CITY OF ELLENSBURG

Memorandum

Date: October 18, 2022
To: Jeremy Cromie, County Planner II
From: Craig Jones, City Development Coordinator *CJ*
Through: Derek Mayo, City Engineer *DKM*
Re: Calvary Church Expansion – RU-22-00003

The following are the City Public Works comments on the Reasonable Use for the proposed Calvary Church Expansion at Vantage Hwy and Cowboy Ln.

**BOUNDARY & TOPOGRAPHIC SURVEY**  
 OF  
**840 COWBOY LN**  
 FOR  
**CALVARY ELLENSBURG**  
 ELLENSBURG, WASHINGTON

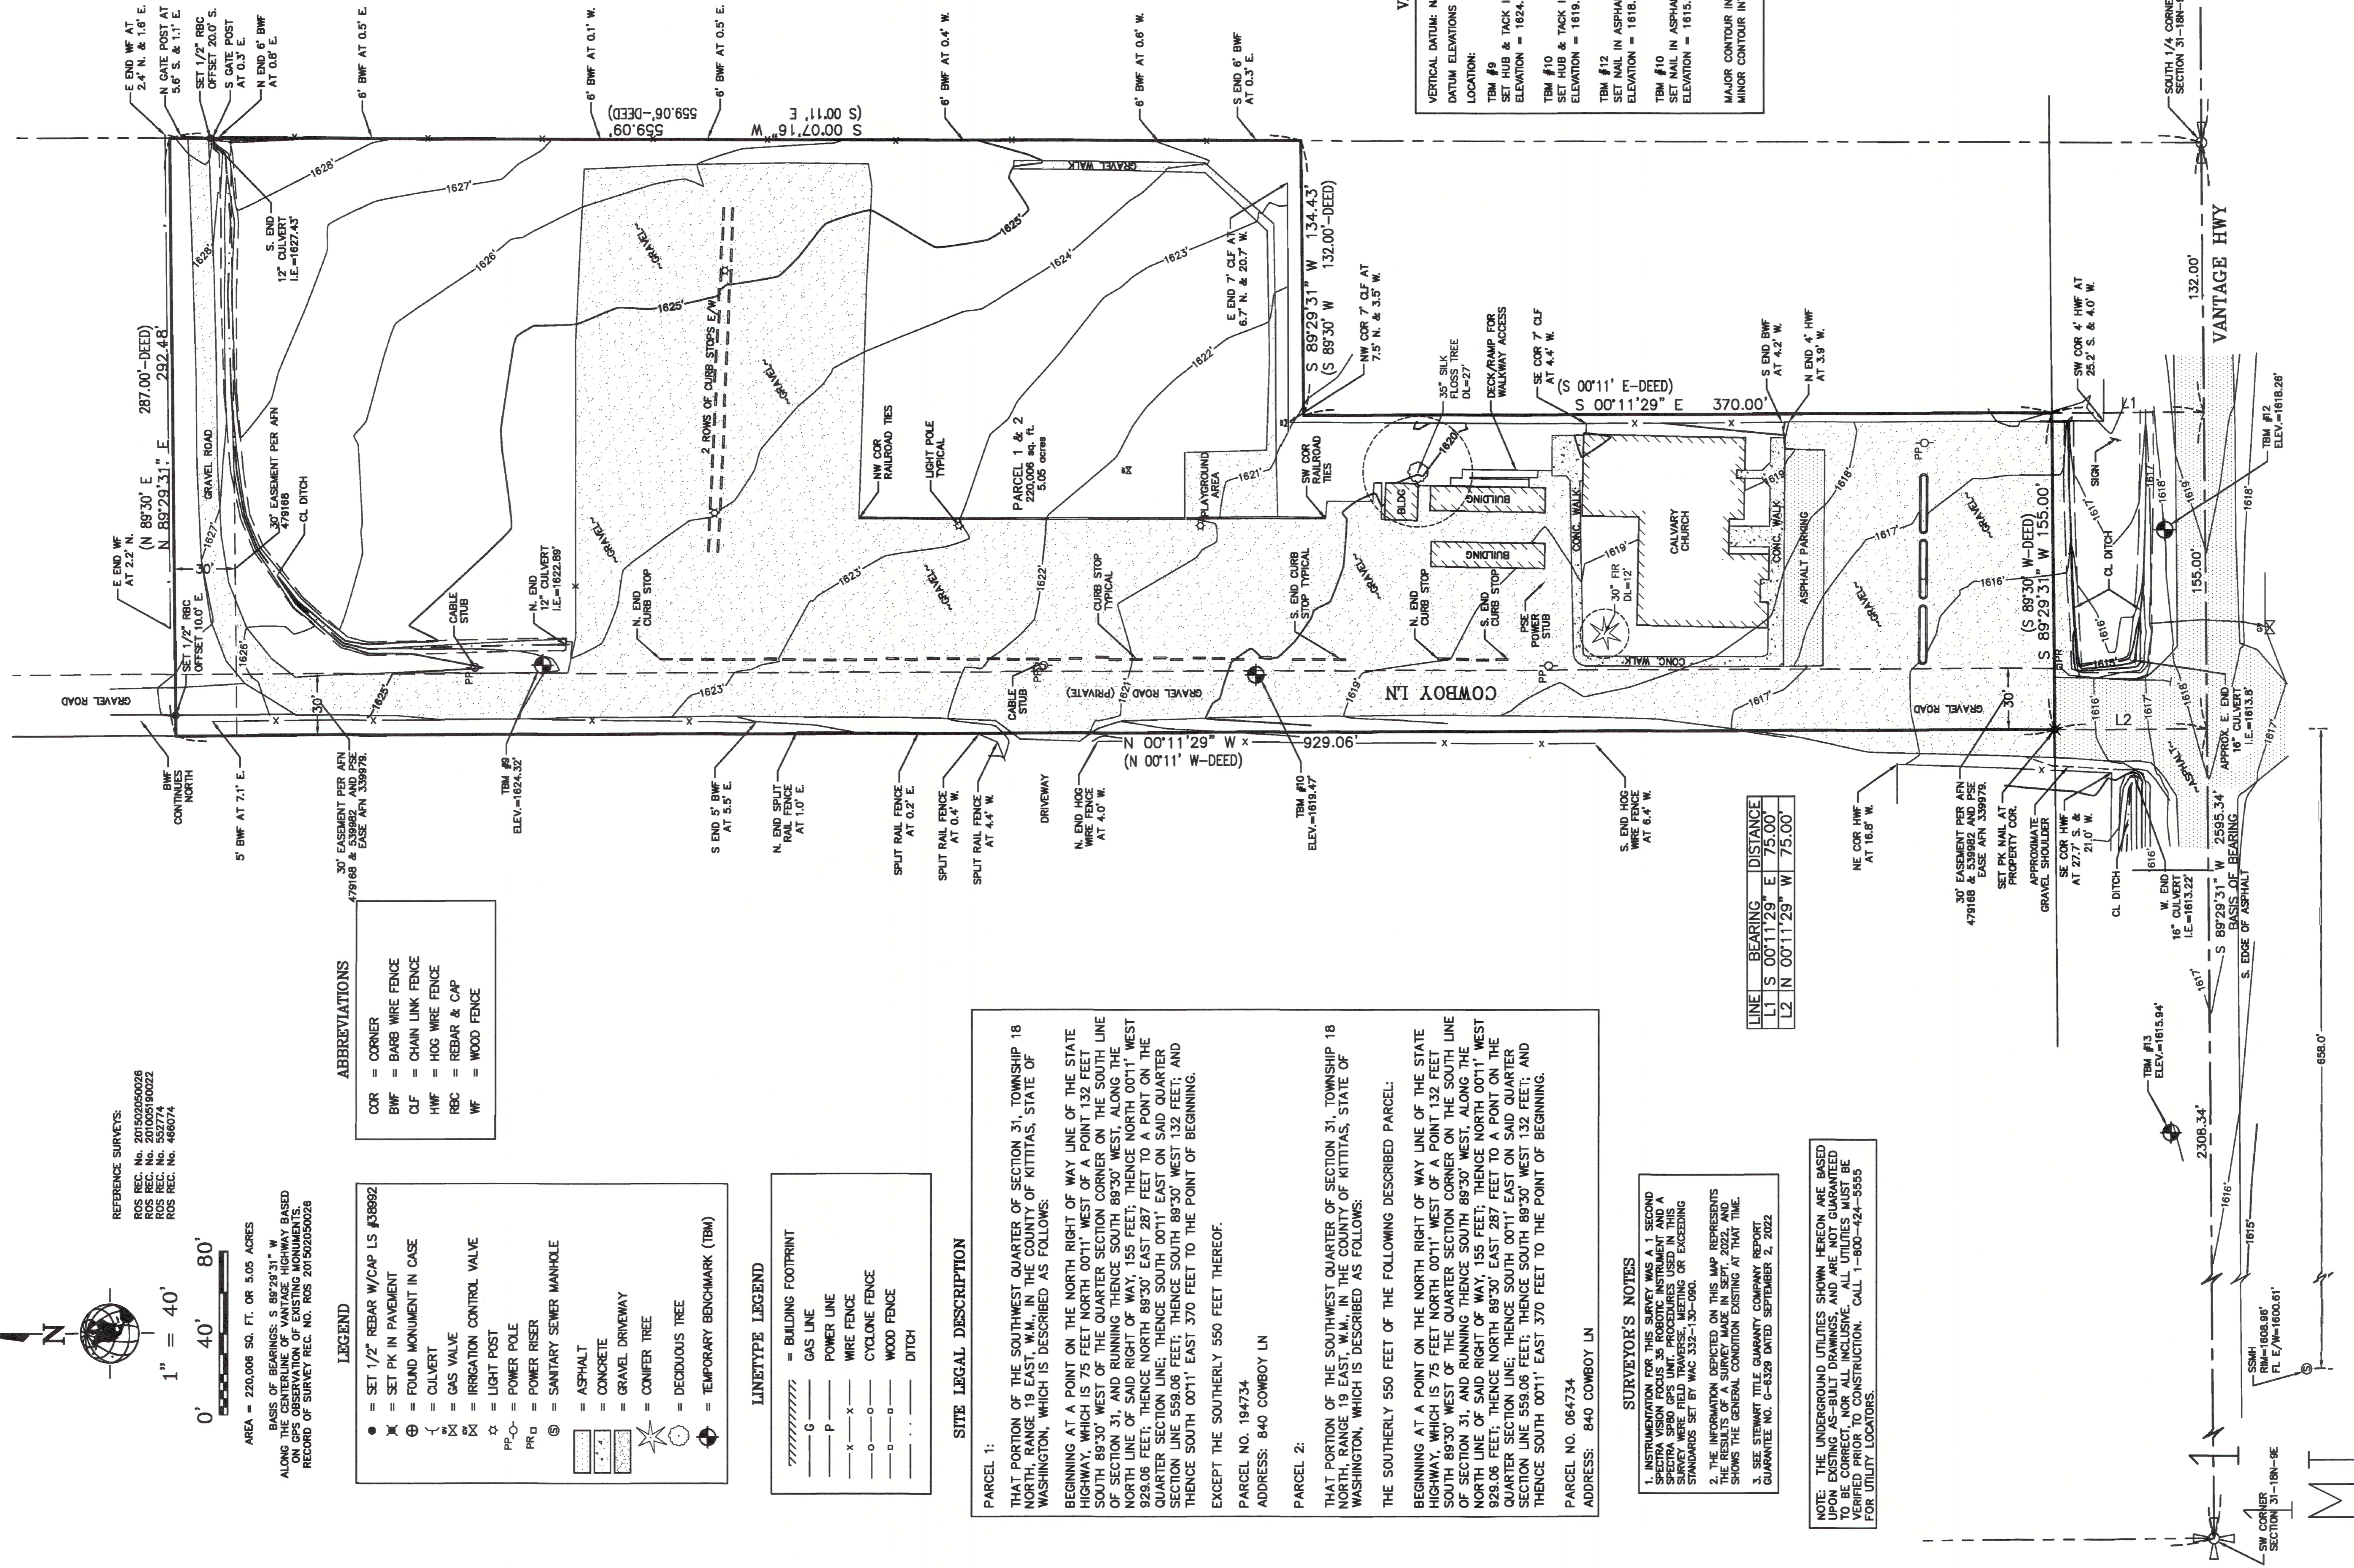
The water main available to serve this development is a 12" Ductile Iron main that runs in Vantage Hwy and stops approximately 680'+/- from the proposed project. The developer will need to extend the main to the farthest east extents of the property being developed along Vantage Hwy. The existing buildings on site will need to connect to City water. See attached utility map.

The sewer main available to serve this development is a 12" PVC main that runs in Vantage Hwy and stops the same location as water. The developer will need to extend the sewer main to the farthest east extents of the property being developed. The existing buildings on site are served by an onsite septic system that will need to be abandoned and connected to City. See attached utility map.

There is a drainage ditch along the south side of the parcel. Stormwater outfall could be discharged here after on site treatment and flow control were met. See attached utility map.
